**Consultation Response from KC,
Highways Development Management**
2021/91362 49, Birkby Lodge Road, Birkby, Huddersfield, HD2 2BE
Erection of single storey extension and garage to rear (modified proposal)
**Date Responded:
11/05/2021**
**Responding Officer: Zack
Turner**
Responding Ref: 5-5NW-30

This application is at 49, Birkby Lodge Road, Birkby, Huddersfield. The proposal is for the erection of a single storey extension and garage to rear.

GROUND FLOOR PLAN

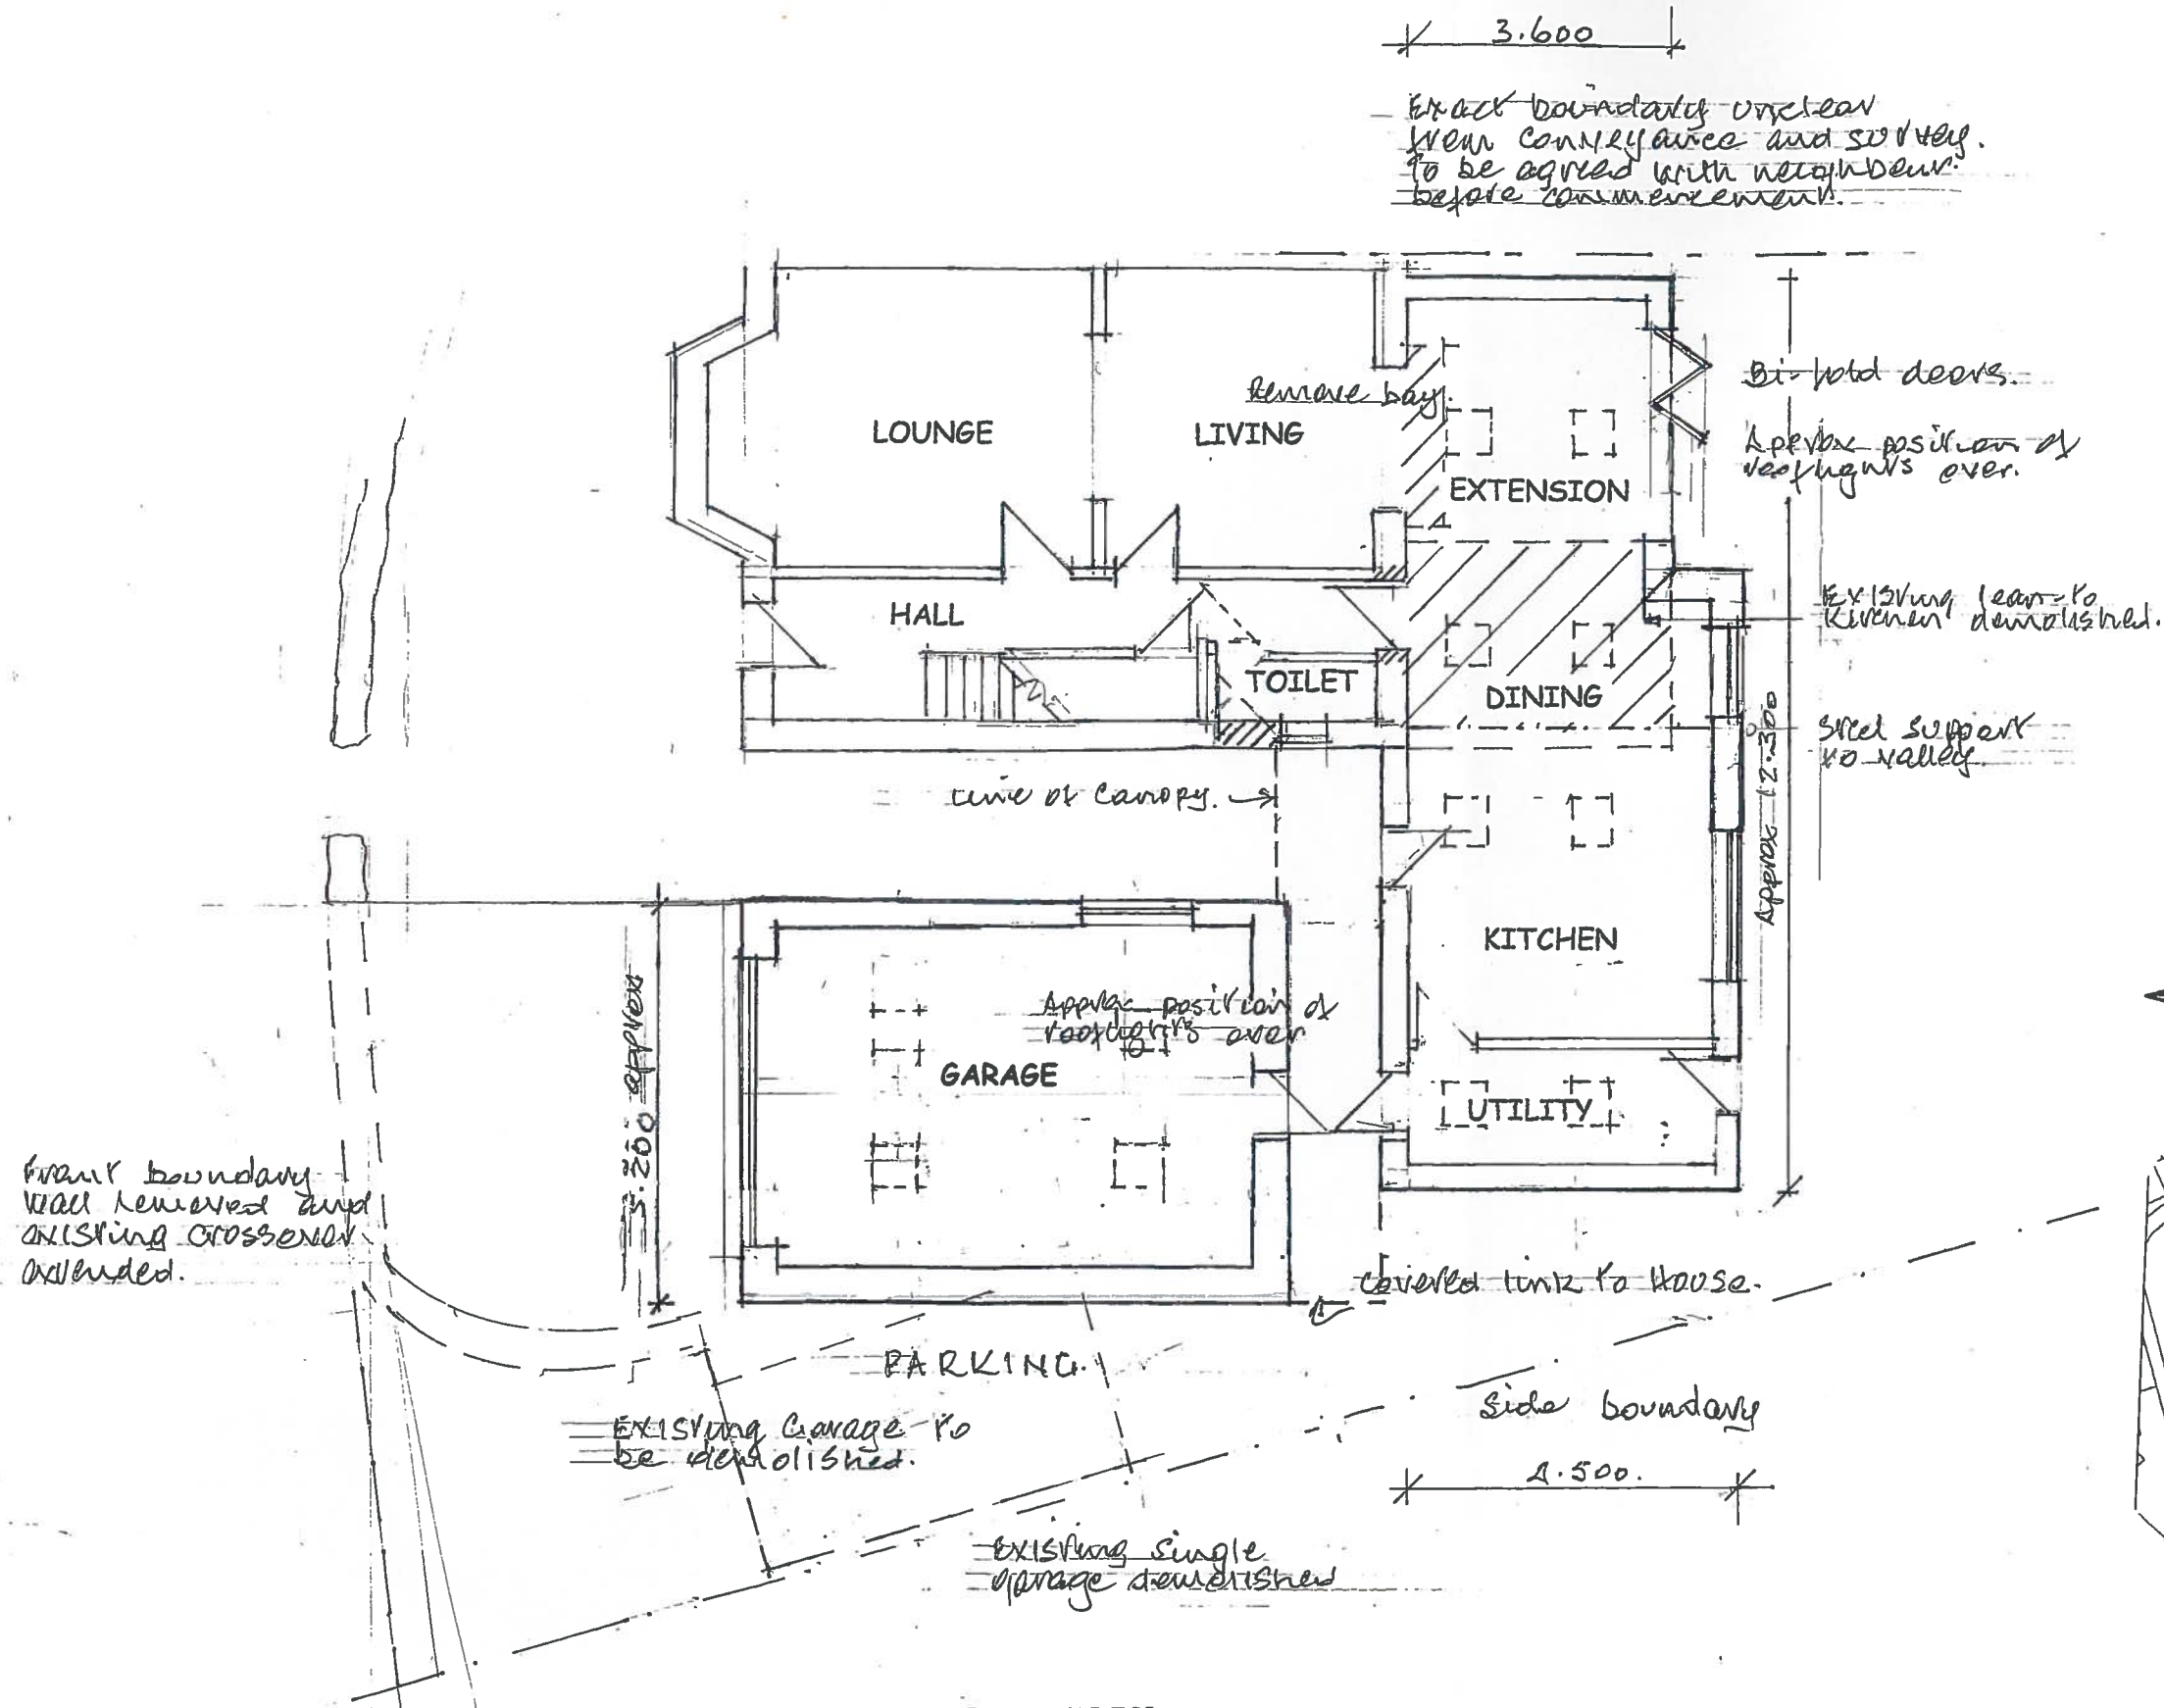
The existing single garage is being demolished as part of the proposals although a new garage is being erected to replace it.

The formation of the new garage will include the works to remove part of the current wall and the works for an extended dropped kerb that will need to be done under a s184 agreement.

Presumably bin storage arrangements will remain as existing although HDM requests that this is confirmed on a plan and this will be conditioned. If the information can be provided prior to determination, then the condition can be removed.
